Department of Primary Industries

Our ref: FE14/28864

Re: Koolewong Marina modifications

TITLE			
LAYOUT PLAN SCHEME 6			
Scale	Dwg No.	Amdt	
1:750 @ A3	PPP SK6-01	B

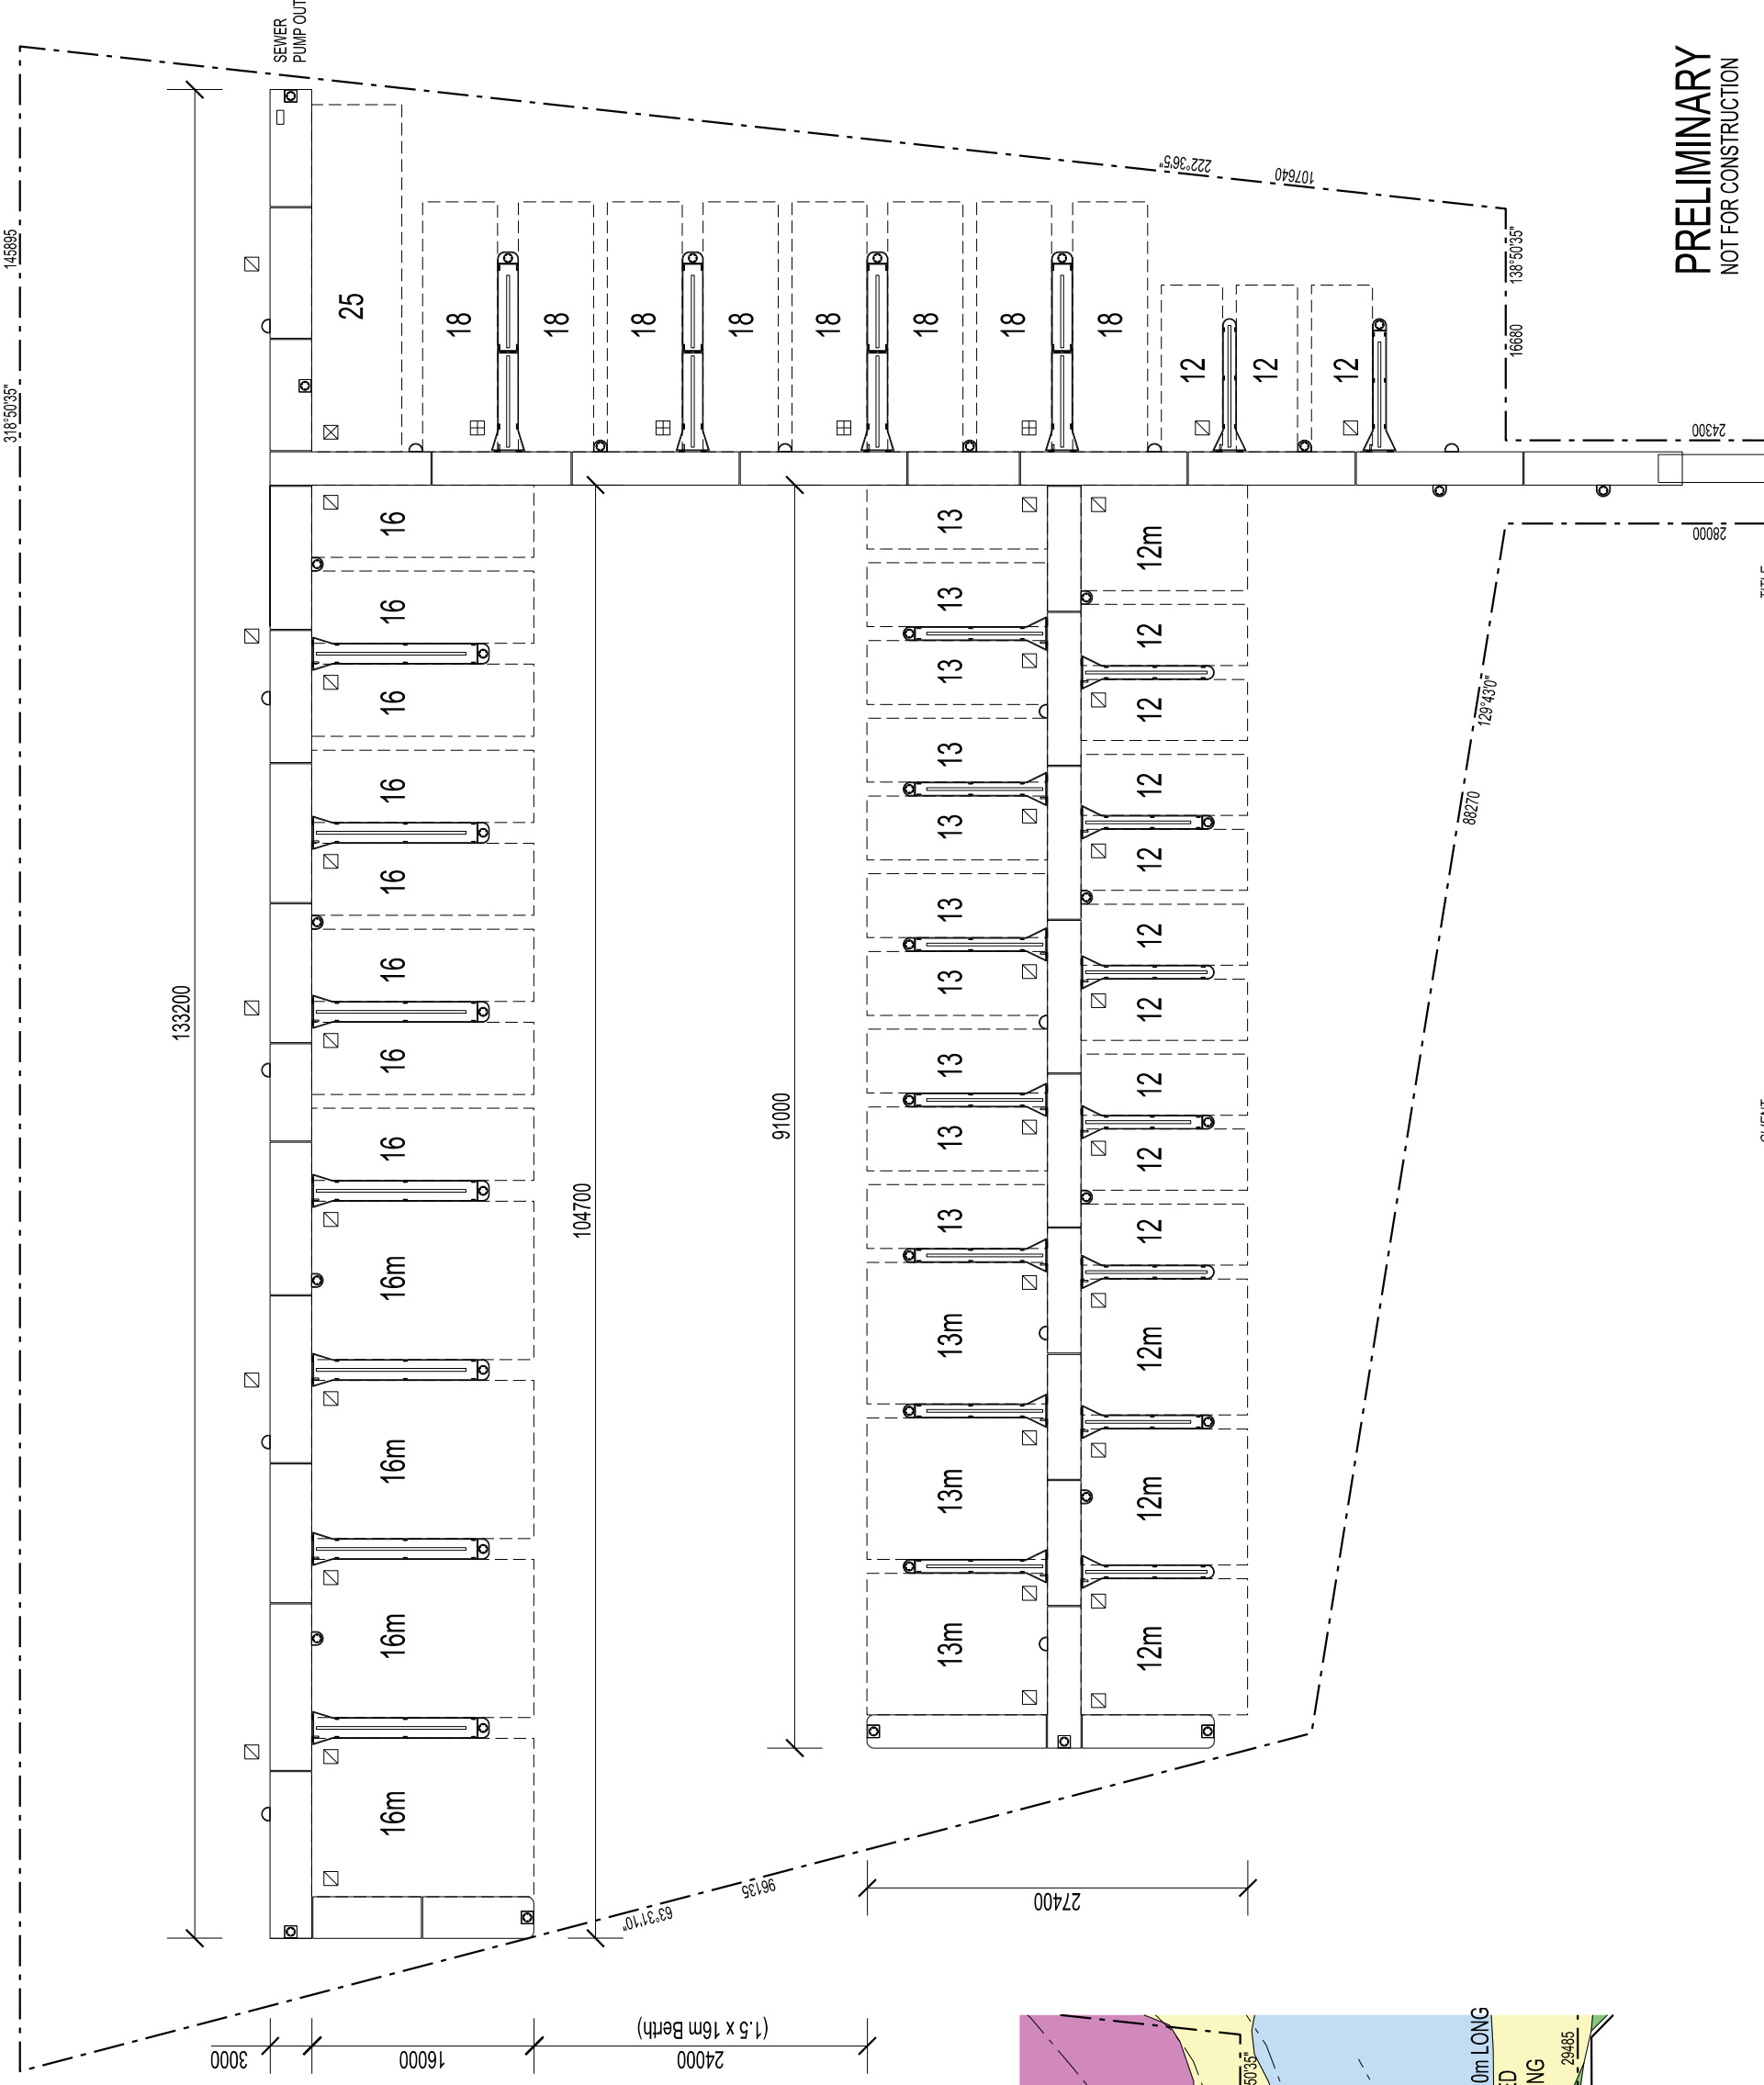
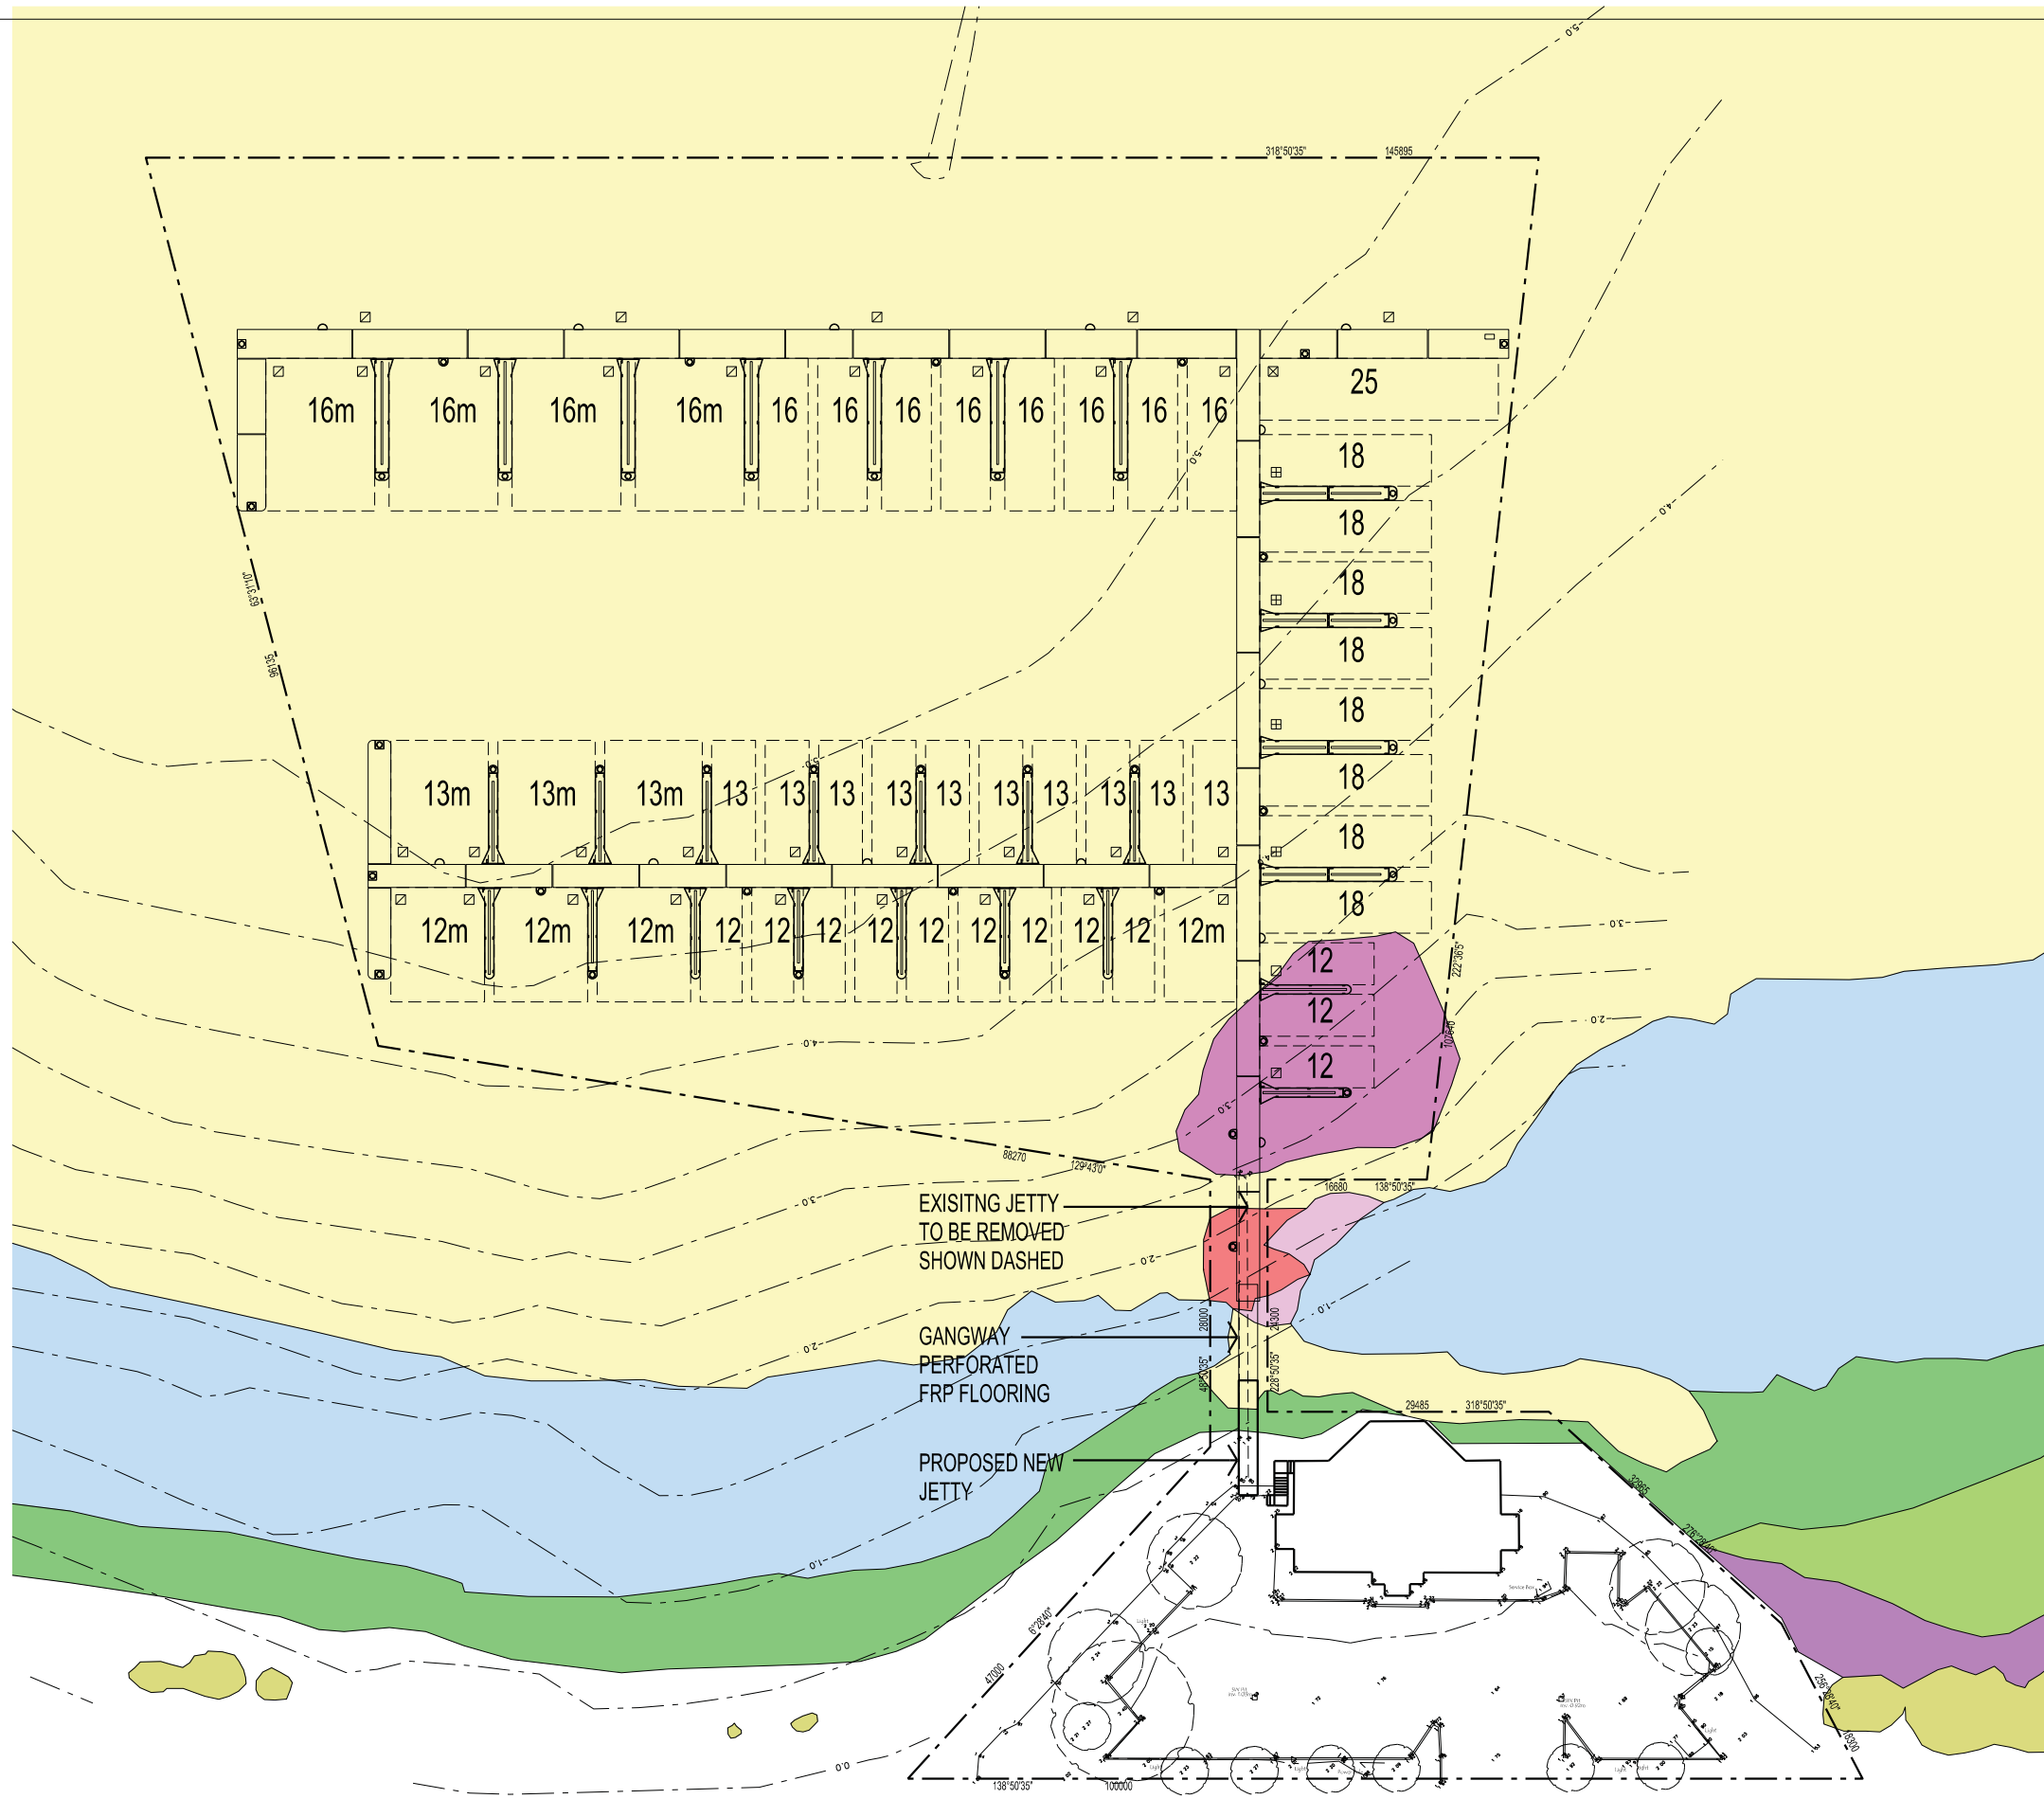
- move the structure closer to the shoreline and the use of meshed decking material are acceptable to the department, and
- [Cardno's Option A mapping, which only investigates seagrass in the vicinity of the existing jetty, to confirm the seagrass is similar to their 2011 Seagrass Mapping report](#) is also adequate to purpose from the Departments view.
